Rezoning Transportation Analysis

Petition Number: 2023-012

From: Jake Carpenter, PE
Jacob.carpenter@charlottenc.gov
980-221-5675

Date	Description
5-24-23	First Review (PDM)
6-21-23	Second Review (DR)
8-23-23	Third Review (PDM)
9-20-23	Fourth Review (JP)

RZ1.0

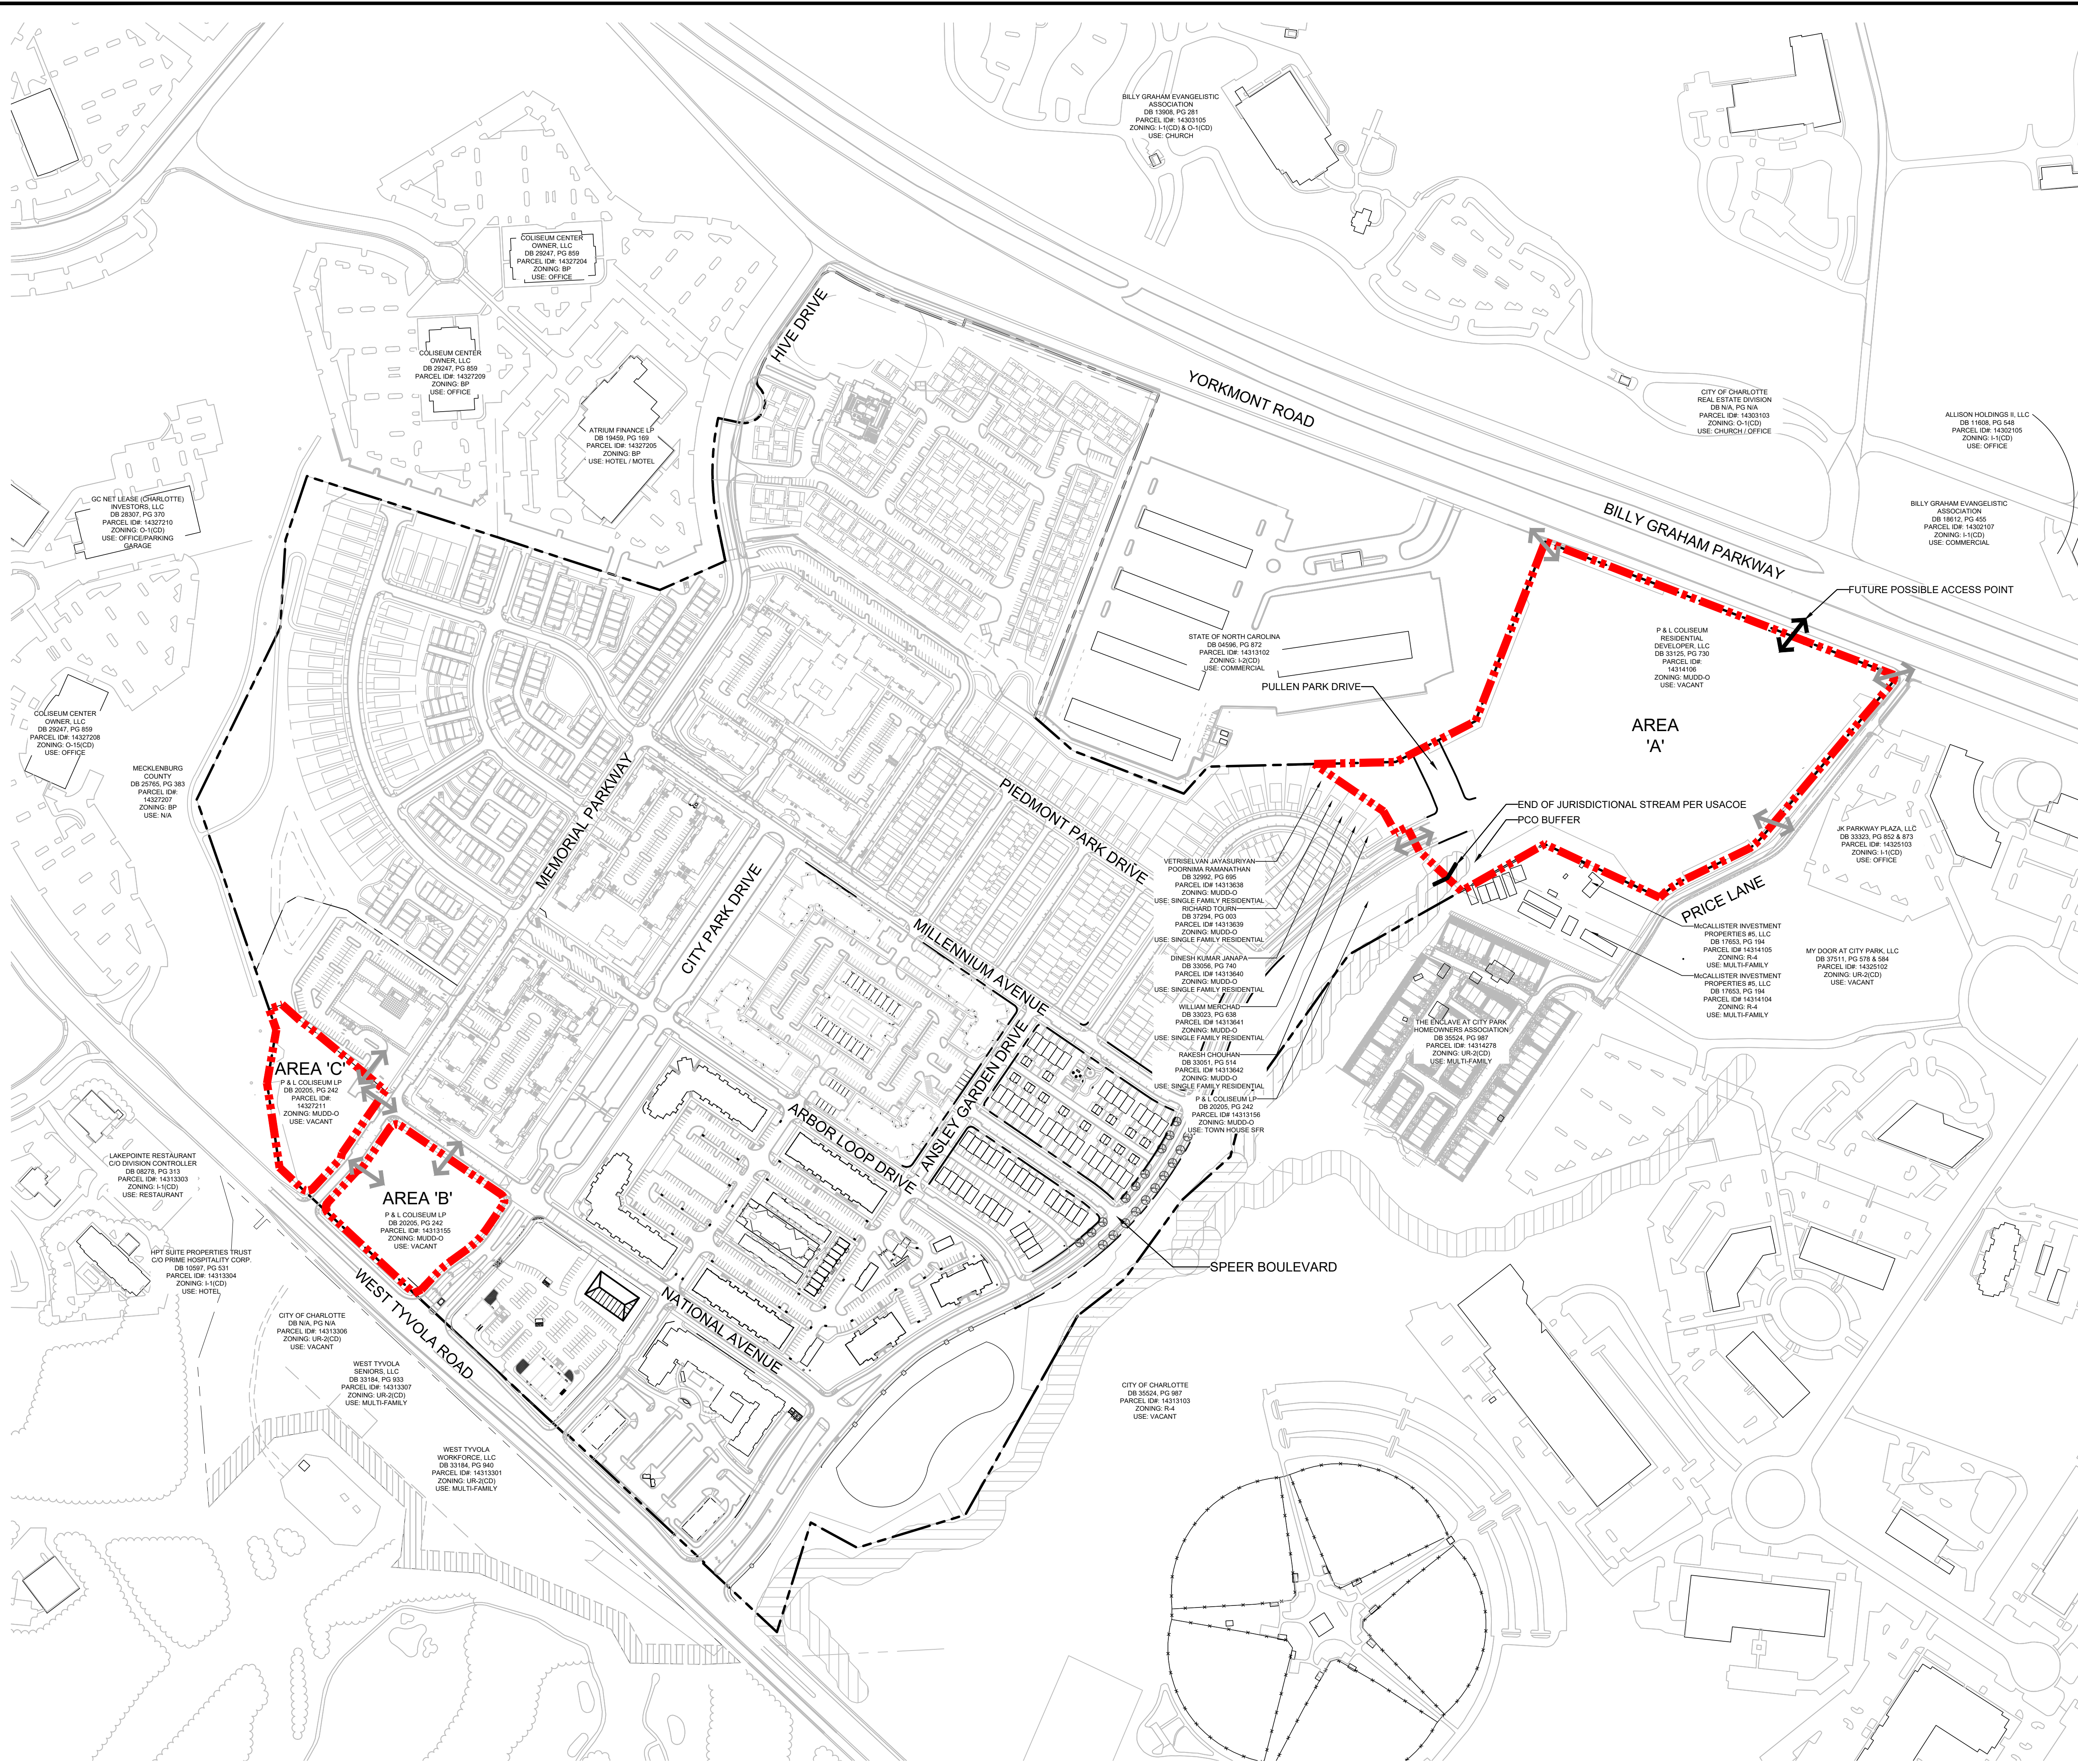
~~Label and dimension the curb and gutter from the centerline for each road on the site plan.~~

Outstanding Comment from 6.21.23: ~~Label and dimension the curb and gutter from the centerline for each road on the site plan.~~

- ~~3. Revise site plan and conditional note(s) to commit to dedicate a minimum of 35 feet of right-of-way from the road centerline on Yorkmont Road and Speer Boulevard. The site plan shall label and dimension the right-of-way from the road centerline.~~

Clarifying comment 6.21.2023: Add conditional note to dedicate a minimum 35 feet of ROW from the roadway centerline of Yorkmont Road and Speer Boulevard. Additionally label and dimension.

Clarifying comment 6.21.2023: Add conditional note to provide 8 foot planting strip and 8 foot sidewalk along Yorkmont Road and Speer Boulevard. Additionally, revise to show 8 foot sidewalk.

5. ~~Revise site plan and conditional note(s) to commit to construct bicycle facilities by locating the curb and gutter 18.5' on Speer Boulevard and 24' on Yorkmont Road from the center line/installing a bike lane to meet the Council adopted Charlotte BIKES Policy.~~

Clarifying comment 6.21.2023: Add conditional note to construct bicycle facilities on Speer Boulevard and Yorkmont Road.

Clarifying comment 6.21.2023: Add conditional note about ROW dedication to the City for possible future Speer connection to Billy Graham Parkway. Speer Road Stub needs to be extended to property line if it will not tie into Billy Graham Parkway.
